**Jacobs Douwe Edberts, Ruscote Avenue,  
Banbury, Oxfordshire, OX16 2QU**

**22/01944/NMA**

**Proposal:** Omission of cladding following demolition; relocation of one car parking space; removal of speed bumps; and revision to pedestrian crossing to provide improved pedestrian access (proposed as non-material amendment to 21/04144/F)

**Proposed CS North and South Elevations**

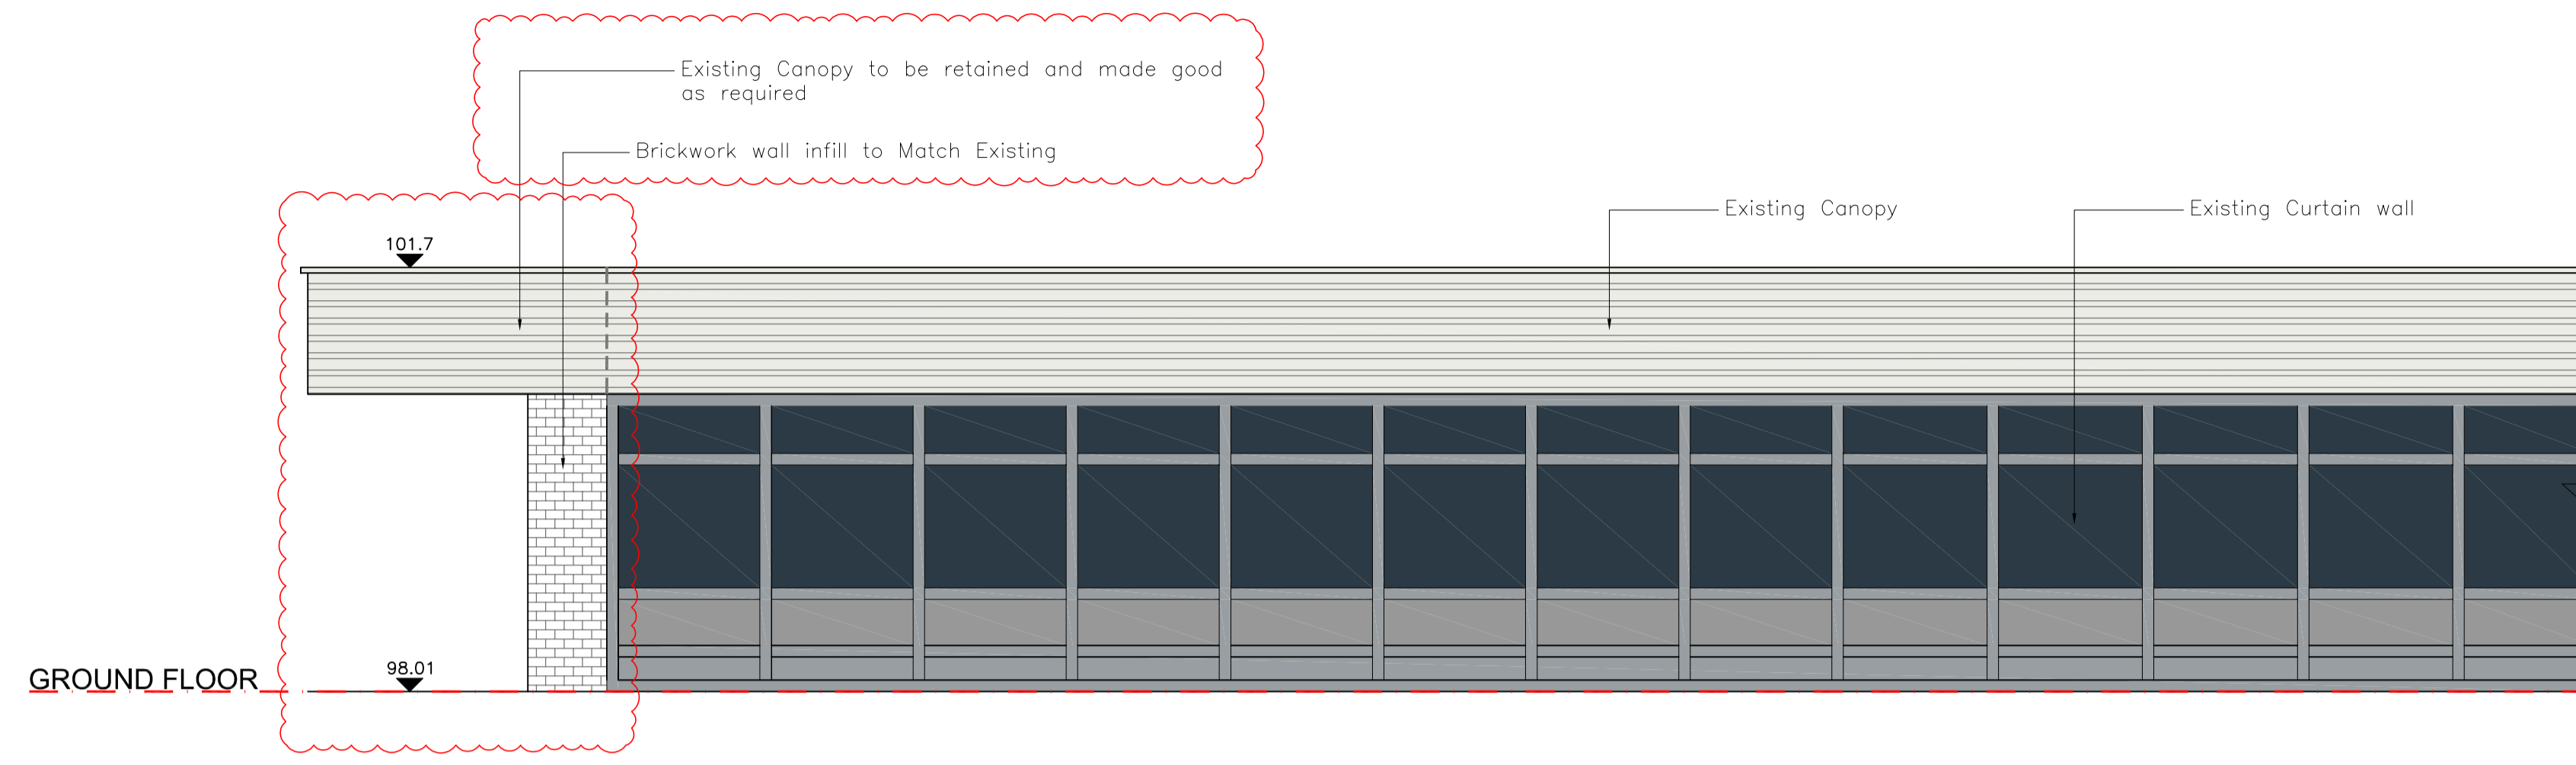
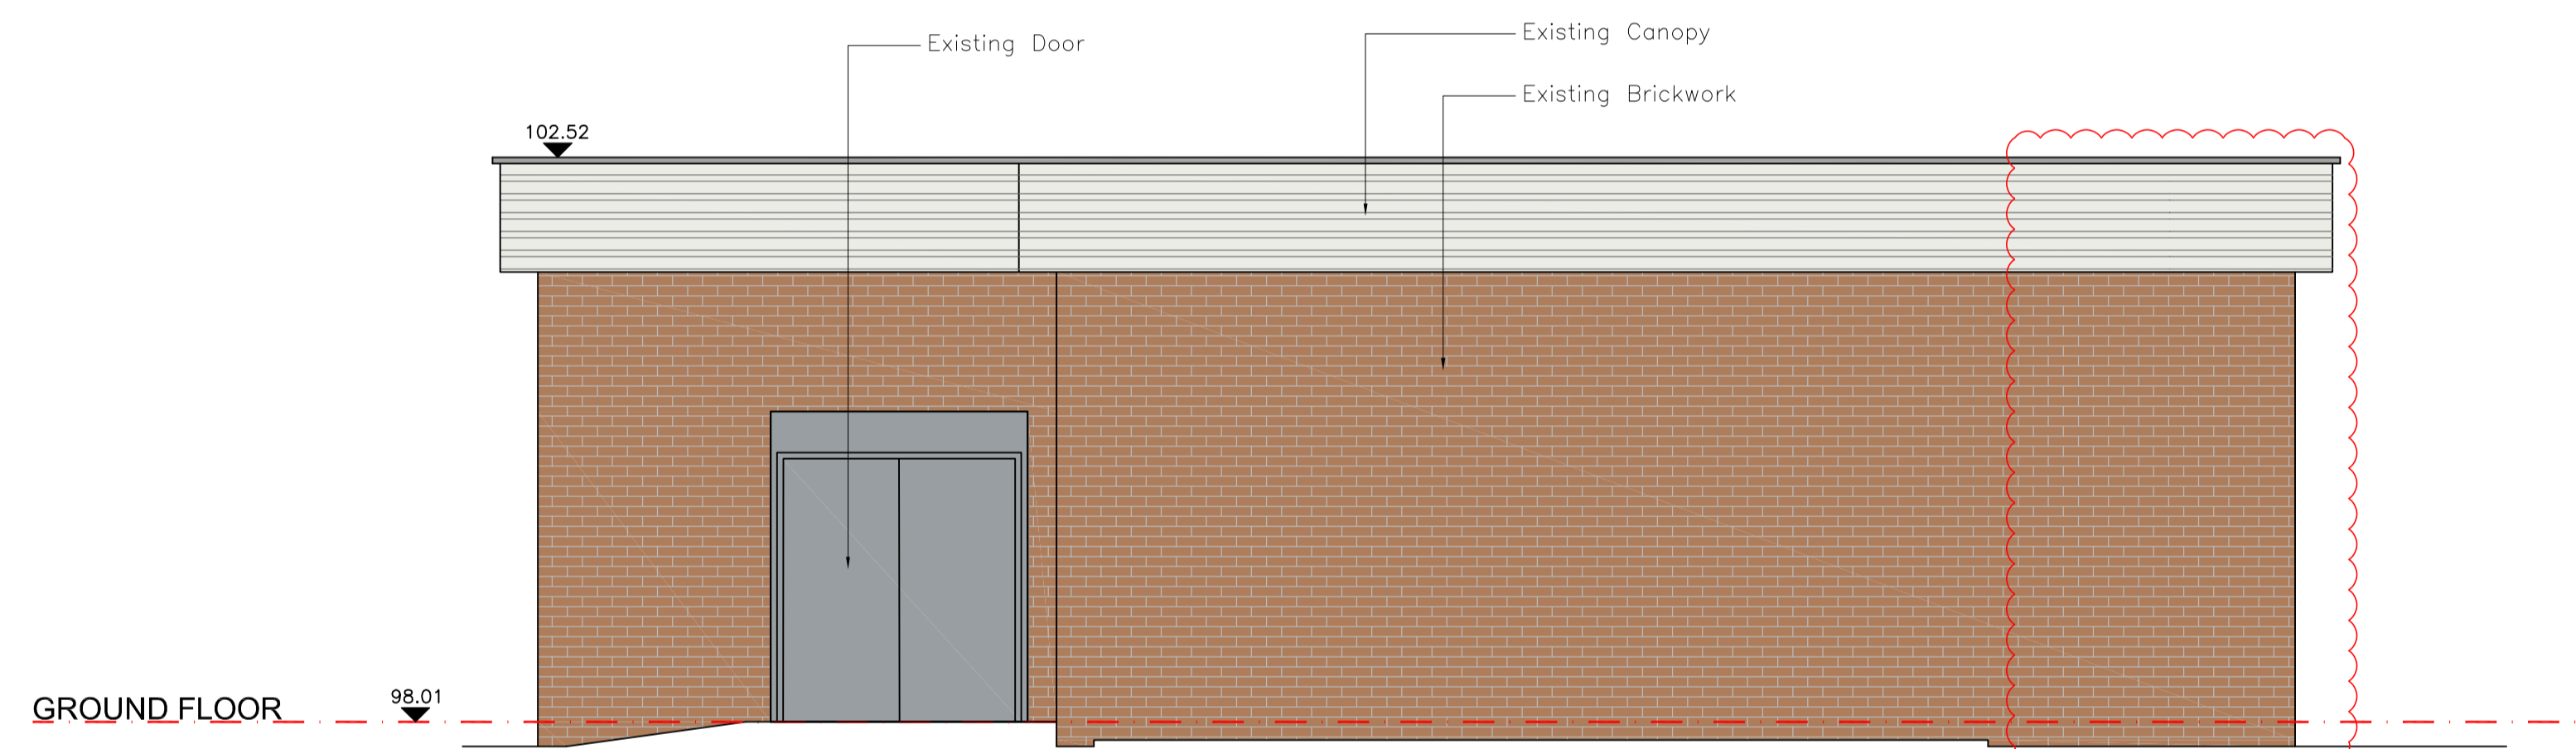
- 5.4. Whilst the omission of the cladding would result in a change to the proposed materials, it would be replaced with brick to match the existing building and would not introduce a different material that would affect the external appearance of the building.

TITLE
Proposed Ground Floor Plan CS

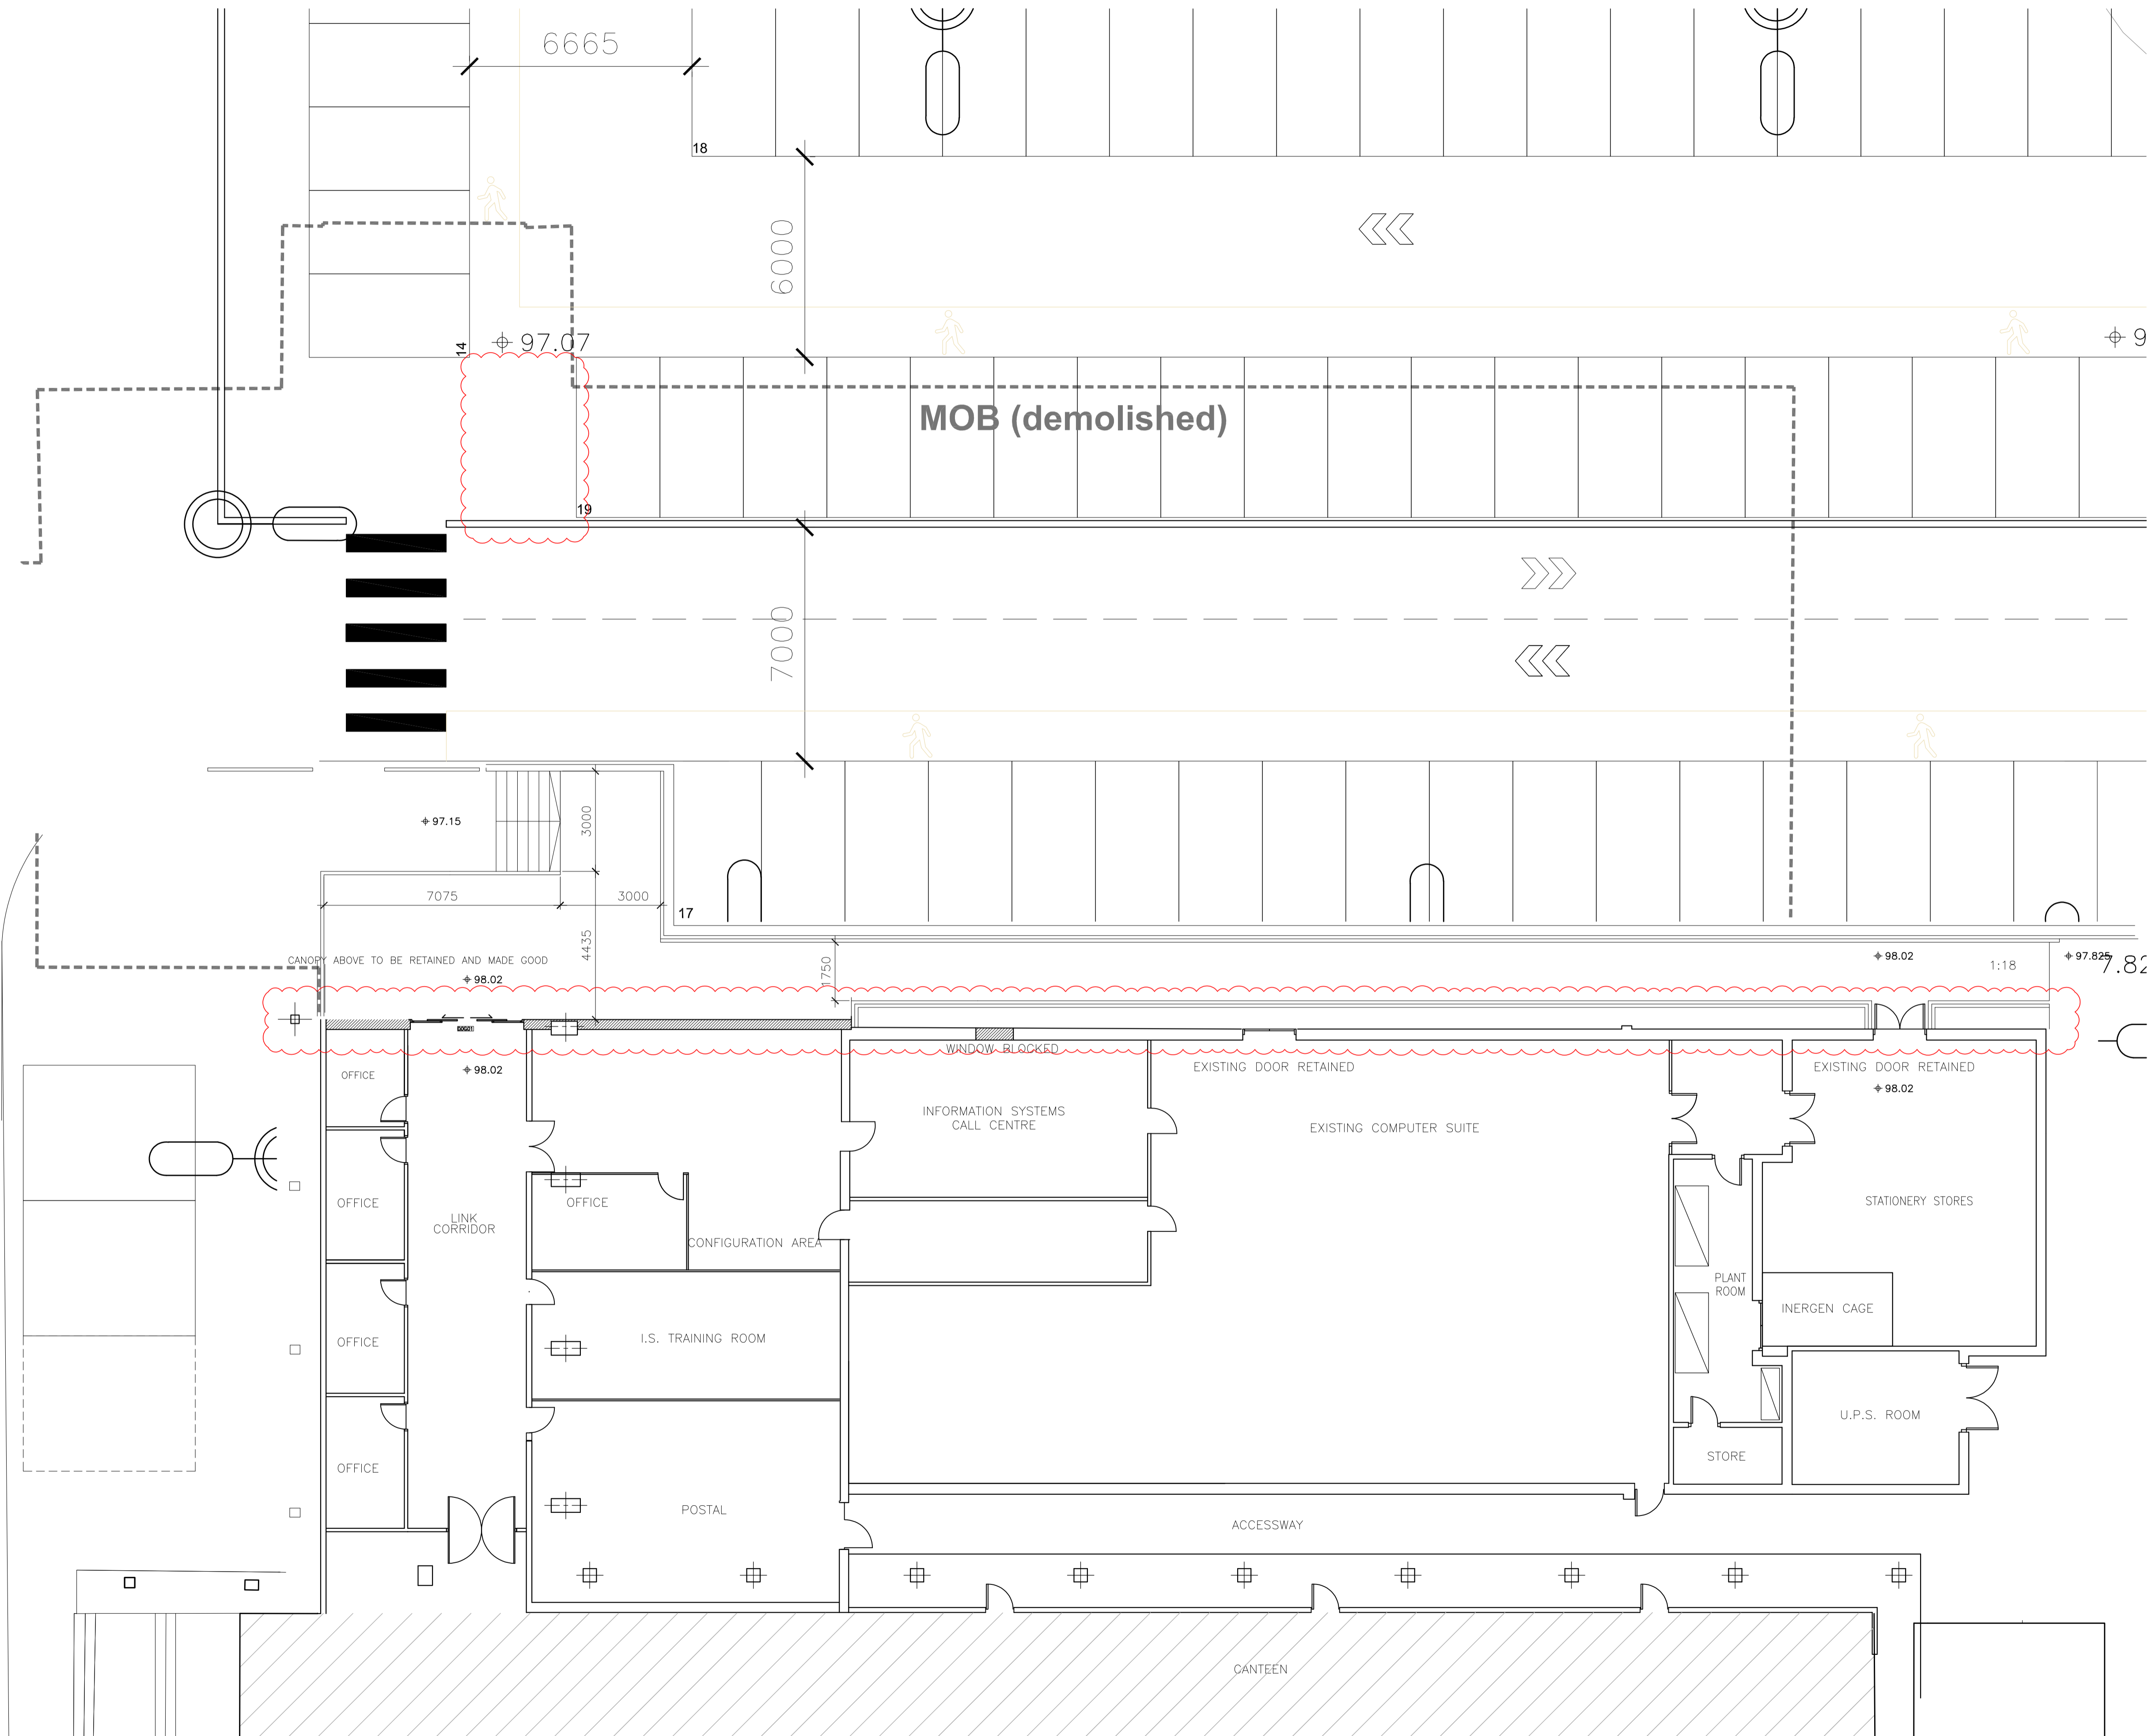
- 5.5. The relocation of the parking space would make it easier to access and would enable a gap for pedestrian access into the car park. The number of parking spaces would remain as approved. Importantly, the proposed change would not raise any new issues or require further consultation.

- 5.6. The remaining alterations to the car park, with the removal of the speed bumps and the re-alignment of the pedestrian crossing at the entrance to the car park would not affect the overall development as approved.
